# Boston Alternative Energy Facility

## Statement of Common Ground between Alternative Use Boston Projects Limited and Boston Borough Council

Planning Inspectorate Reference Number: EN010095

Date: ~~February~~March 2022

BOSTON ALTERNATIVE ENERGY FACILITY DEVELOPMENT CONSENT ORDER
 Regulation 5(2)(k) - Access and Rights of Way Plan
 BOSTON BOROUGH COUNCIL
 Sheet 1 of 1

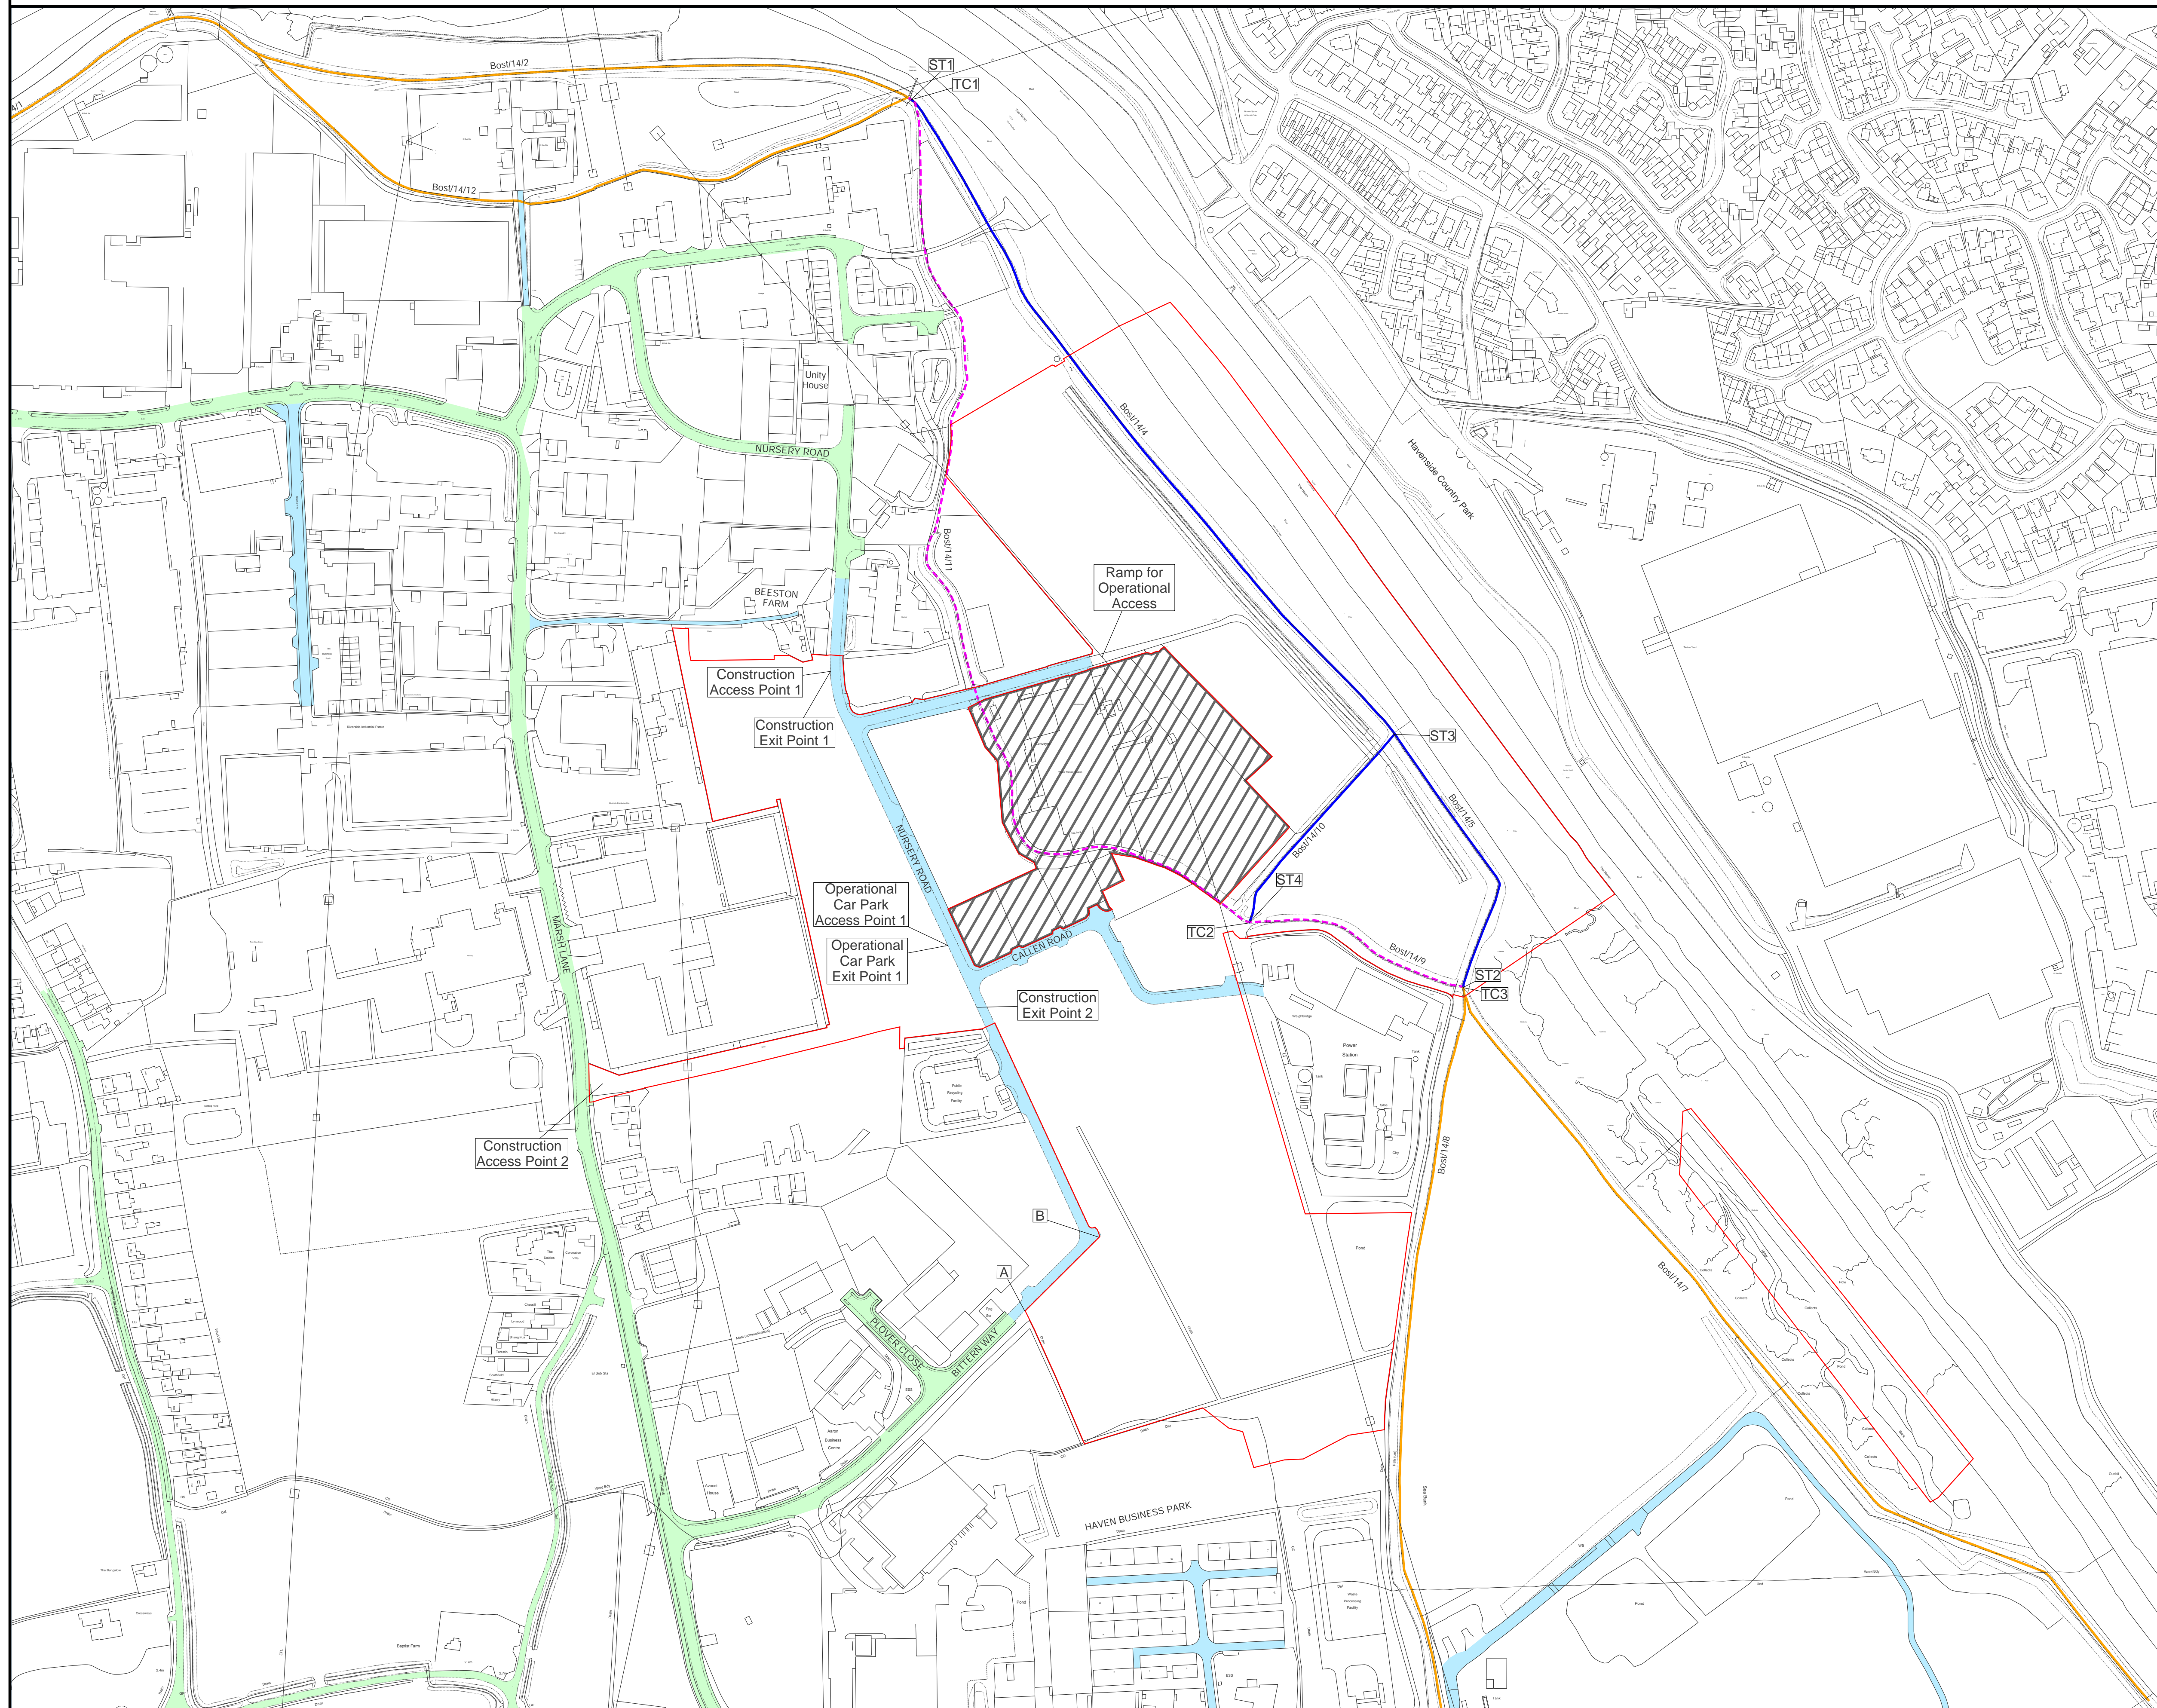
SoCG Reference	Document Reference	Topic	BBC's Position	AUBP's Position	Status
			any residual impacts of the scheme are managed/mitigated, albeit accepting that this may fall outside of the planning process. We remain committed to discussion and dialogue with AUBP on this.		
<b>4. Public Rights of Way (PRoW), recreation and tourism</b>					
BBC 4.1	ES Chapter 19 (Traffic and Transport) (Doc ref 6.2.19, APP-057)	PRoW Stopping Up	<p>We would query why the loss of PRoW is considered minor and suggest this should be upgraded. Concerns that this element has been under assessed and not properly understood. We question whether the PRoW permanent closures have been underplayed and whether sufficient mitigation has been presented.</p> <p>BBC requests a detailed scheme for works to improve the PRoW including measures such as boundaries, detailed design for the footbridge, footpath width, planting, surfacing, signage, vegetation management, interpretation, management for a set period.</p> <p>The Council notes that the submitted Outline PRoW Design Guide and</p>	<p>Approximately 1.1 km of footpath will be permanently stopped up alongside The Haven. An Outline PRoW Design Guide and Stopping up Plan for the alternative route (which is an existing PRoW) was submitted to the Examination at Deadline 3 <u>and a revised version was submitted at Deadline 8</u> (document reference 9.41(1), REP83-0407). The work sets proposed improvements to the PRoW including factors such as safety, materials, planting / biodiversity and interpretation and seating. Boston Borough Council have been consulted as part of this work. The outline guide is intended to inform a final detailed design for improvement works to the retained public rights of way and approach and mitigation in relation to the public rights of way due to be permanently stopped up. <u>The draft s.106 provides that AUBP will undertake a number of commitments in relation to</u></p>	<p>Under discussion <u>pending conclusion of s.106</u></p>

SoCG Reference	Document Reference	Topic	BBC's Position	AUBP's Position	Status
			<p>Stopping up plan at Deadline 3 is a step forward. Clearly there is a level of dialogue ongoing to finalise the details, particularly around the funding and management objectives. LCC will have input in to this also.</p> <p>The Council has reviewed the responses to date on this point. We note the steps taken by AUBP to address and that there are proposals for mitigation being presented including through the requirements. It is likely that this matter will be agreed by a subsequent deadline once further submissions have been lodged formally, and a S106 concluded.</p>	<p><u>improving the existing public rights of way including measures to enhance the surfaces, widen the paths where possible, provide seating and additional signage.</u></p>	
BBC 4.2	ES Chapter 20 (Socio-Economics) (Doc ref 6.2.20, APP-058)	Tourism	<p>BBC queries the extent of tourism impact assessment and the limited scope (0.5 miles). We feel this may have been underplayed. We also consider that measures should be put in place to establish and monitor the exact implications on the tourism sector during construction.</p>	<p>The tourism assessment set out in the ES covers a radius on 10 miles from the site. It is considered that the scope and assessment is appropriate. Given the assessments presented within the ES, AUBP does not consider it is necessary to propose any tourism monitoring. At the meeting with the Council on 7 September 2021 this issue was discussed. AUBP maintains it is unnecessary to undertake tourism monitoring.</p>	Agreed
